# Rezoning Transportation Analysis

Petition Number: 2021-082

General Location Identifier: 15720715

Date	Description
08-02-2021	First Review (DBS)
09-17-2021	Second Review (WB)

RZ-1.0

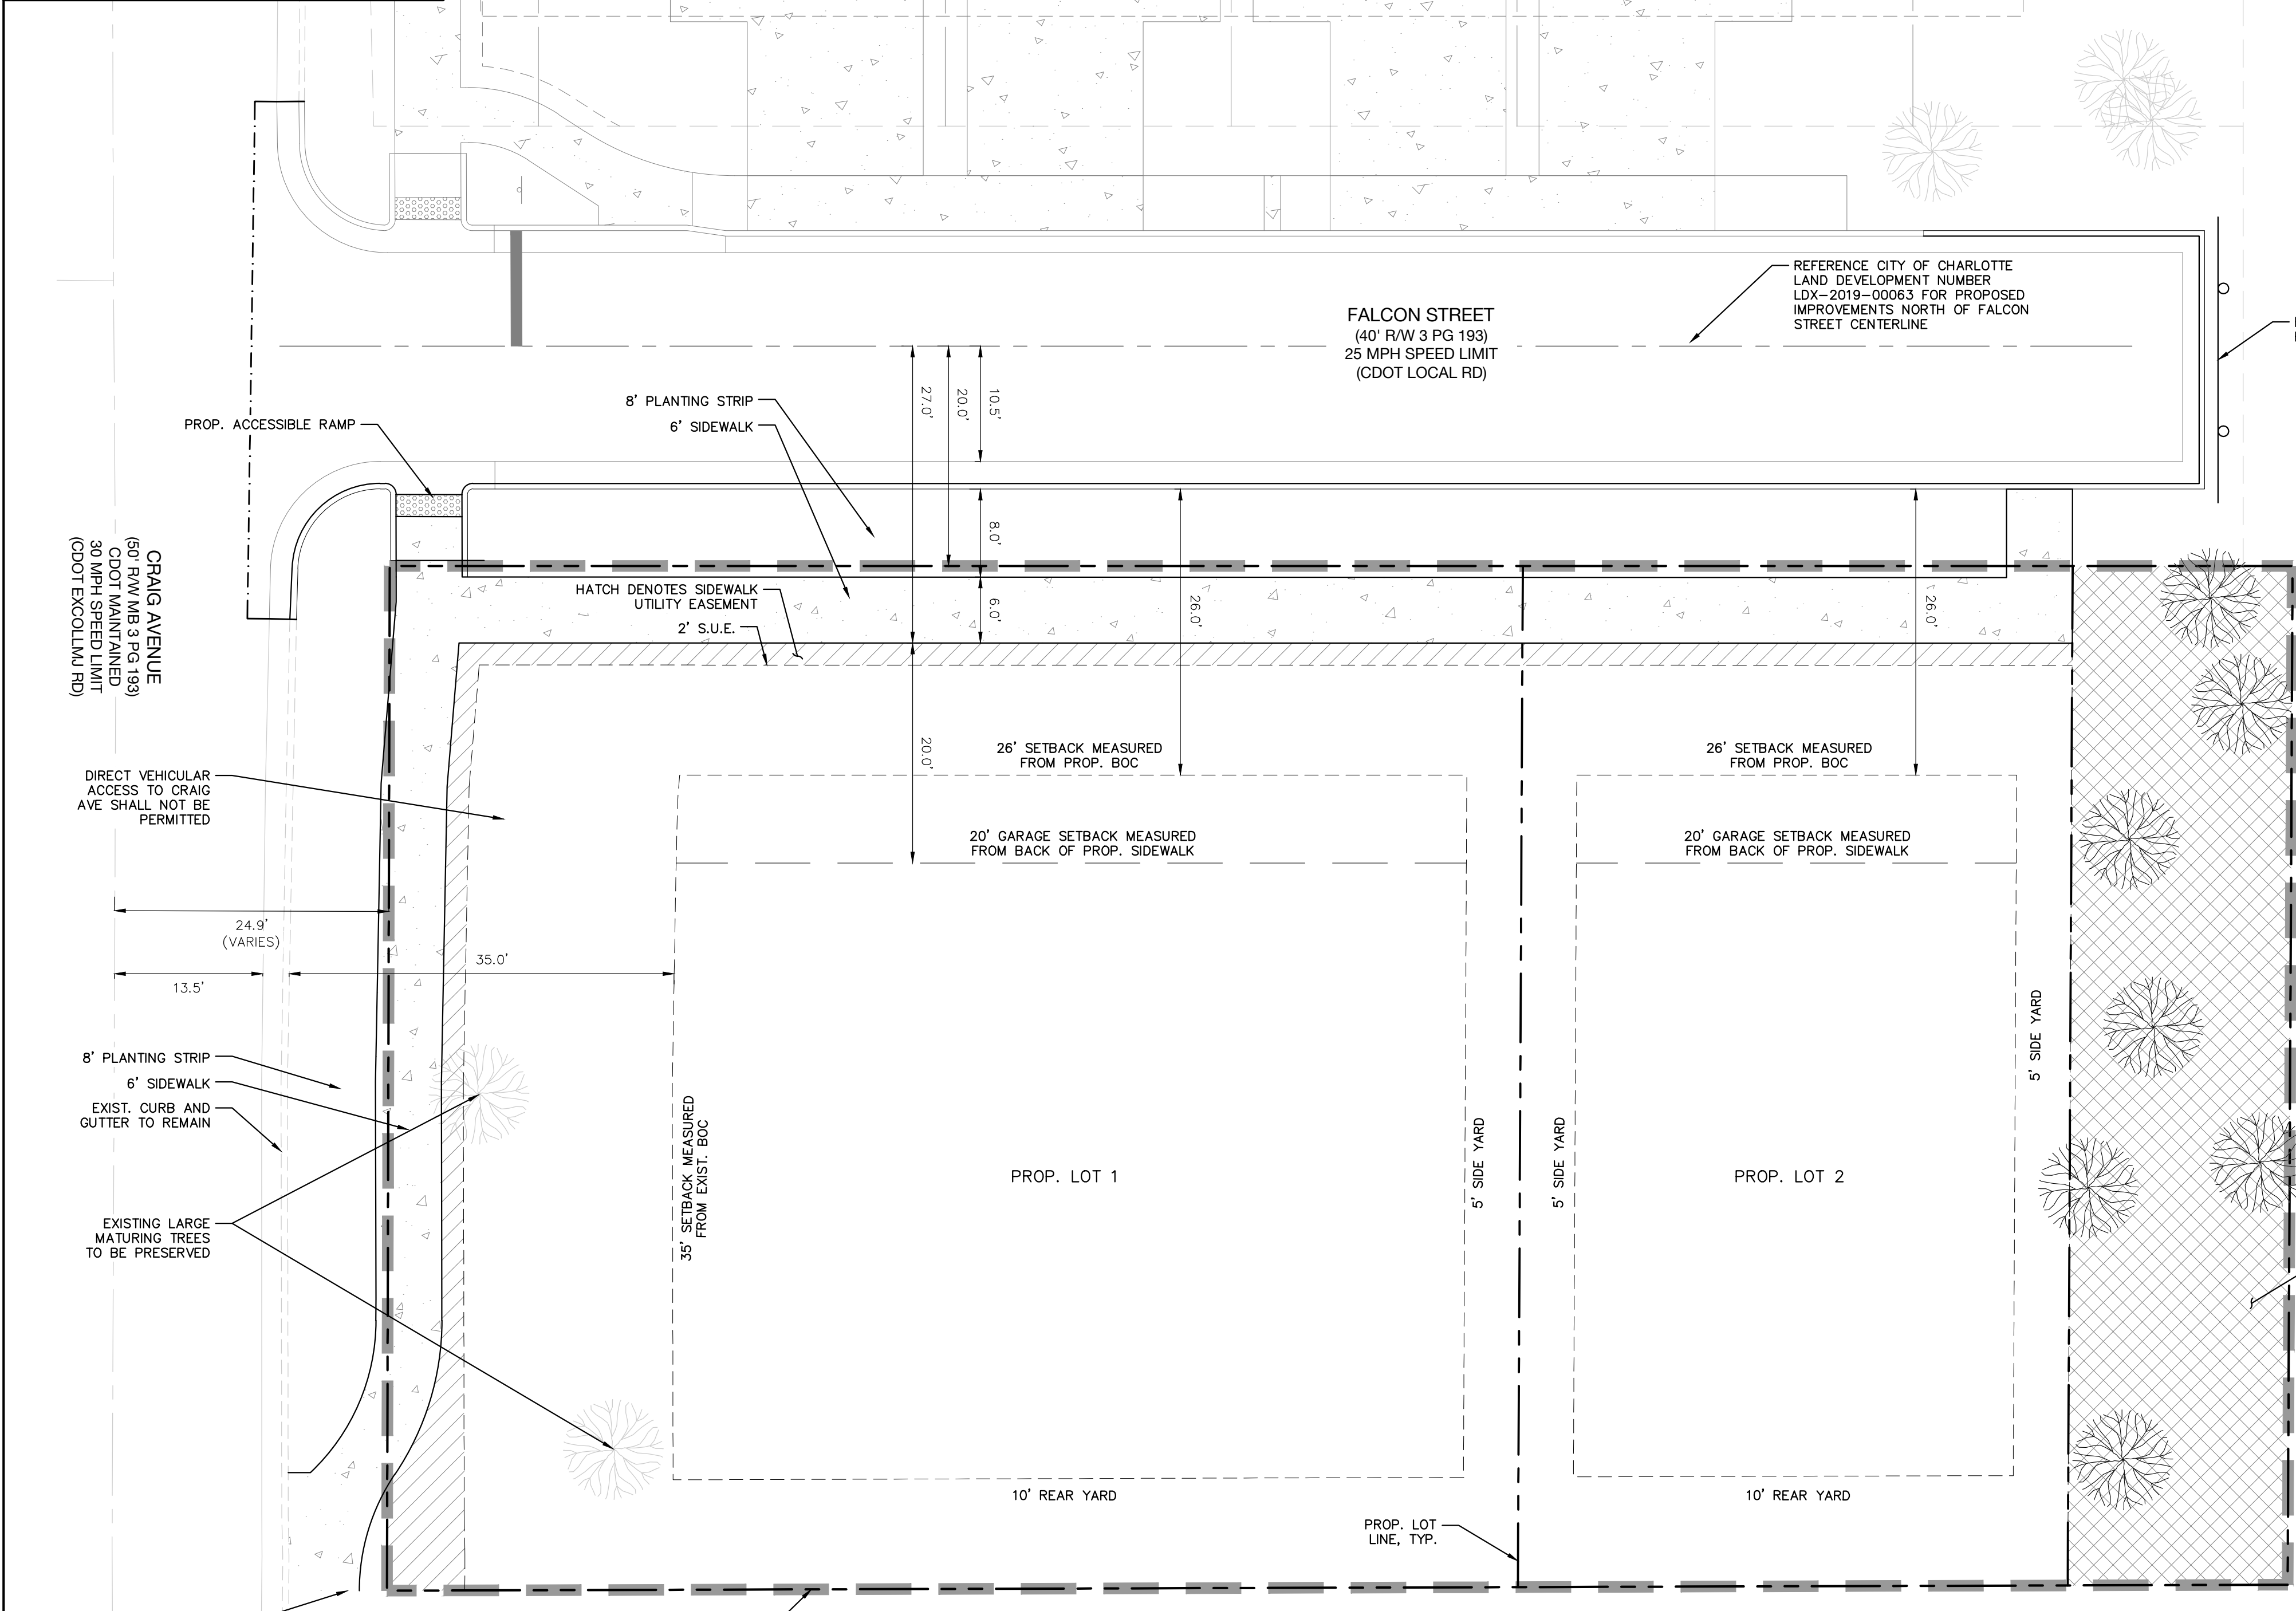
- ~~1. A Traffic Impact Study (TIS) is not necessary for the complete review of this petition due to the site generating less than 2,500 daily trips. If during the permitting process the site generates more than 2,500 daily trips, then a traffic study will be required.~~
- ~~2. Revise site plan note that Falcon Street is City maintained. Although it appears to be public right-of-way, it is not currently City maintained.~~
- ~~3. The residential narrow street type is not valid for this density. Revise site plan accordingly.~~
- ~~4. Revise site plan to reflect the Falcon Street stub extending all the way to the eastern property line.~~
